Able Marine Energy Park

Material Change 2

Statement of Common

Statement of Common Ground

**Consented Quay Design**  
Scale 1:2500

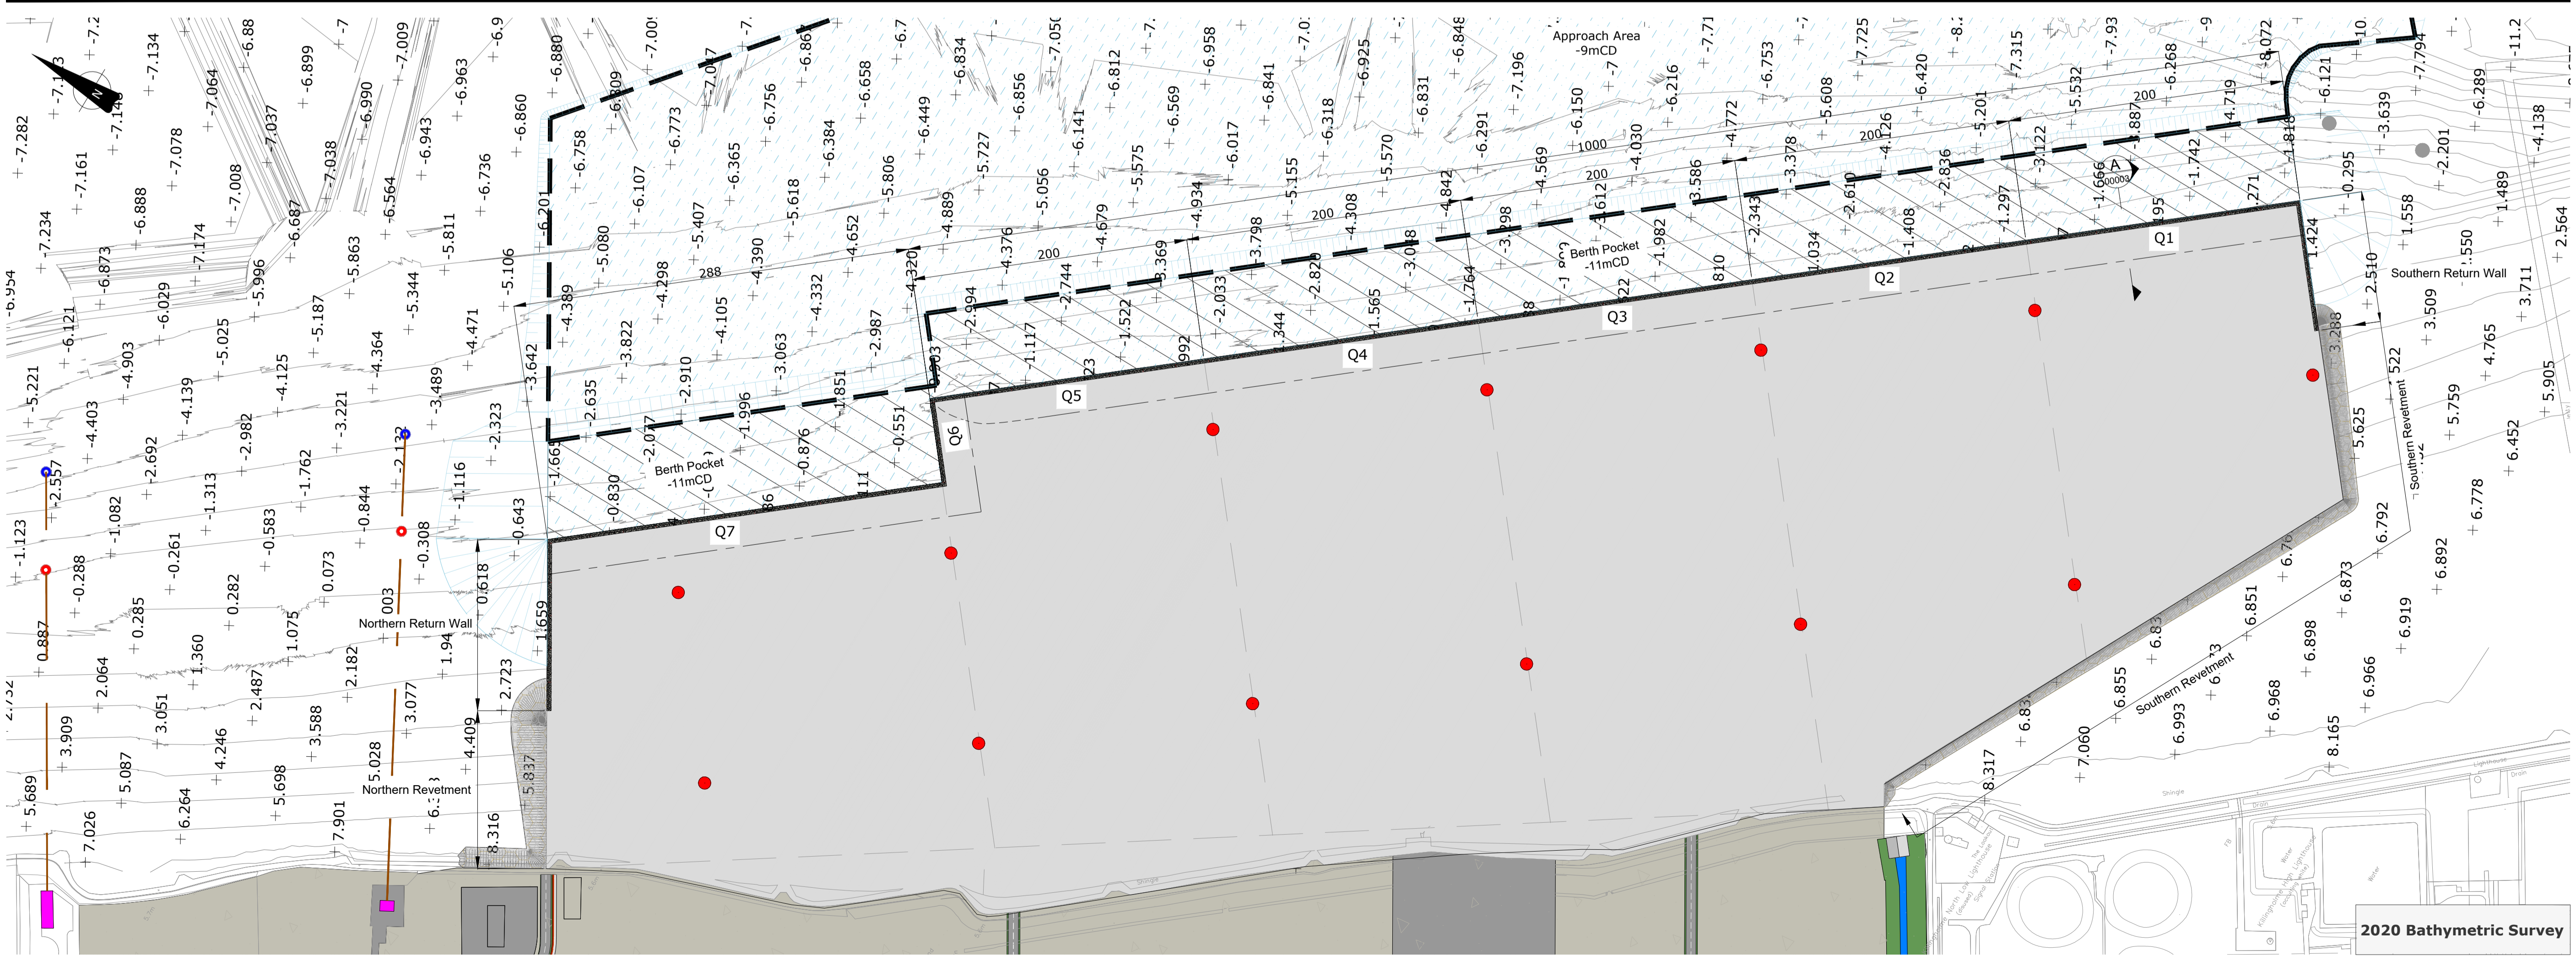
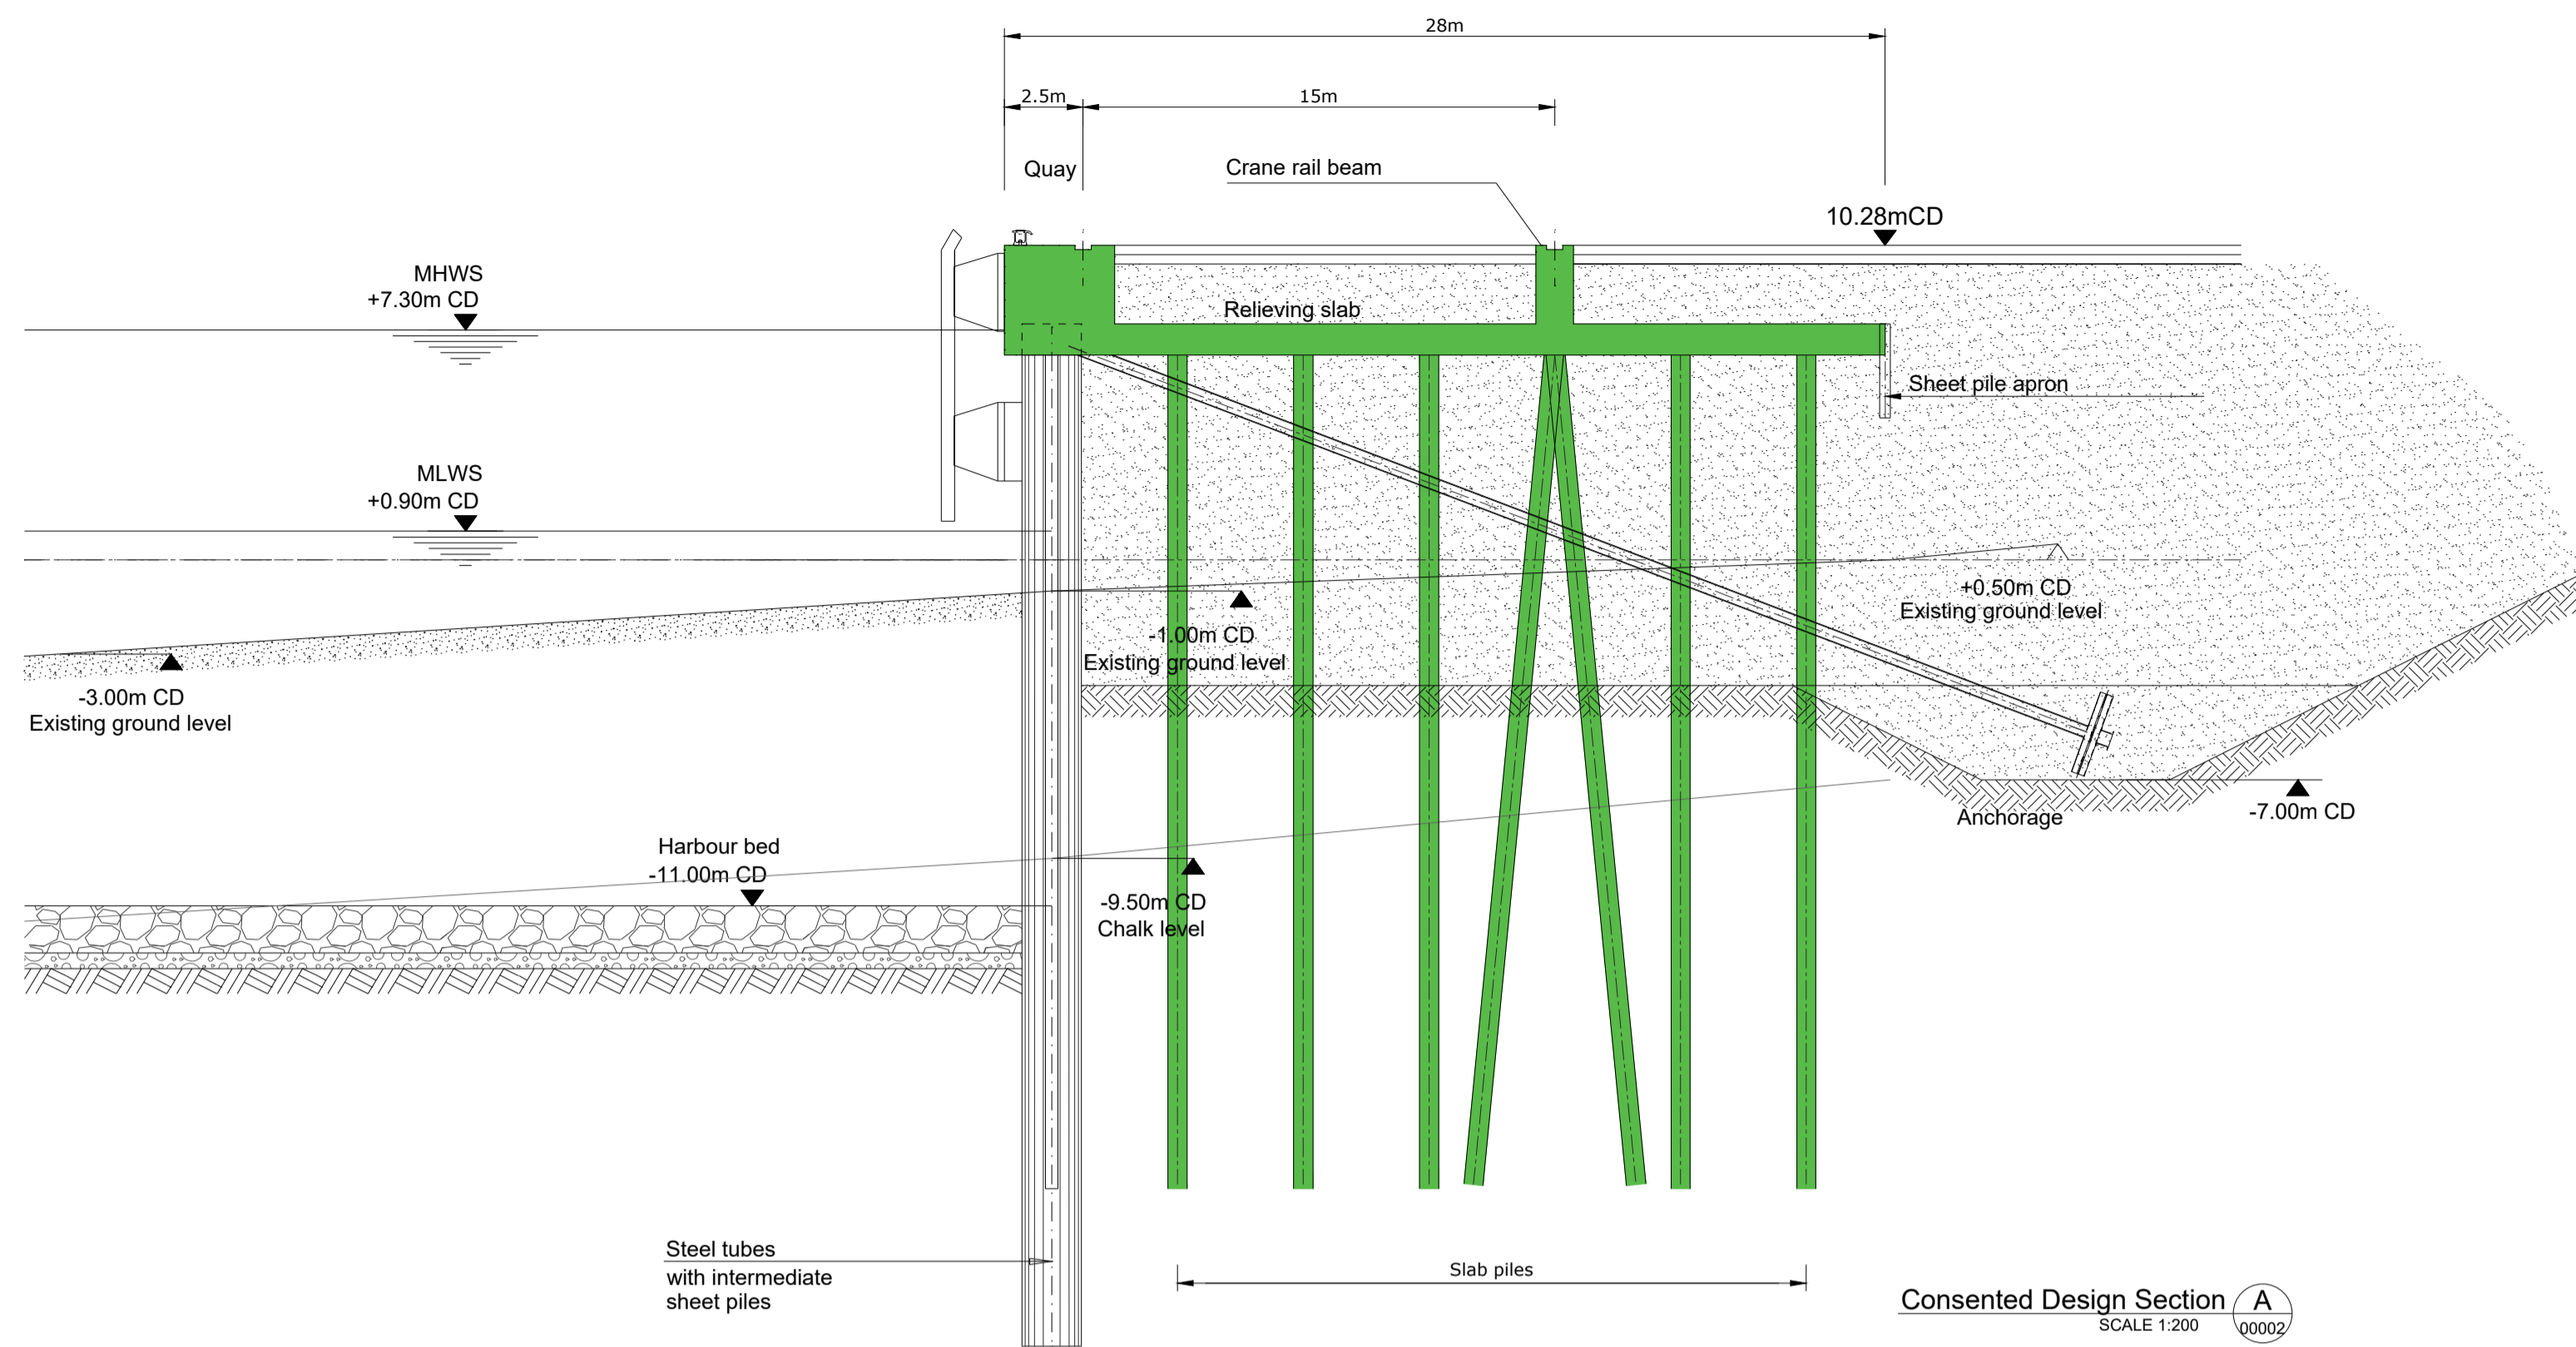
- 4.8 As requested in NE's relevant representations letter dated 23 August 2021, NE recommended that further assessment is required on the potential change in operational effects due to changes to the design of the quay, i.e. vessels will be closer to the SSSI than in the previous design. This change could increase noise disturbance levels at North Killingholme Haven Pits (NKHP), particularly from vessel traffic and port activity. This information should be provided in the HRA in addition to the UES. NE notes that 8.12 of the AA states "There would be no change in the extent of the operational noise disturbance resulting from the proposed material change." However, there is no justification or evidence provided for how this conclusion has been reached.

- 4.9 Section 8.12 of the AA also states: "There would be some change to the planned lighting regime in order to accommodate the new quay alignment, but lighting levels are subject to approval under Schedule 11 of the extant DCO, Requirement 24 and require consultation with Natural England before being approved by the local planning authority". NE therefore advises that further clarification is also required as to the potential impacts from lighting as a result of the changes to the quay design.

- 4.7 The Applicant has confirmed that there would be no change in the extent of the noise disturbance resulting from the proposed material change as the quay piling will be no closer as consequence of the proposed changes, as set out in section 16.4.0 of Chapter 16 of the UES (APP-087)..
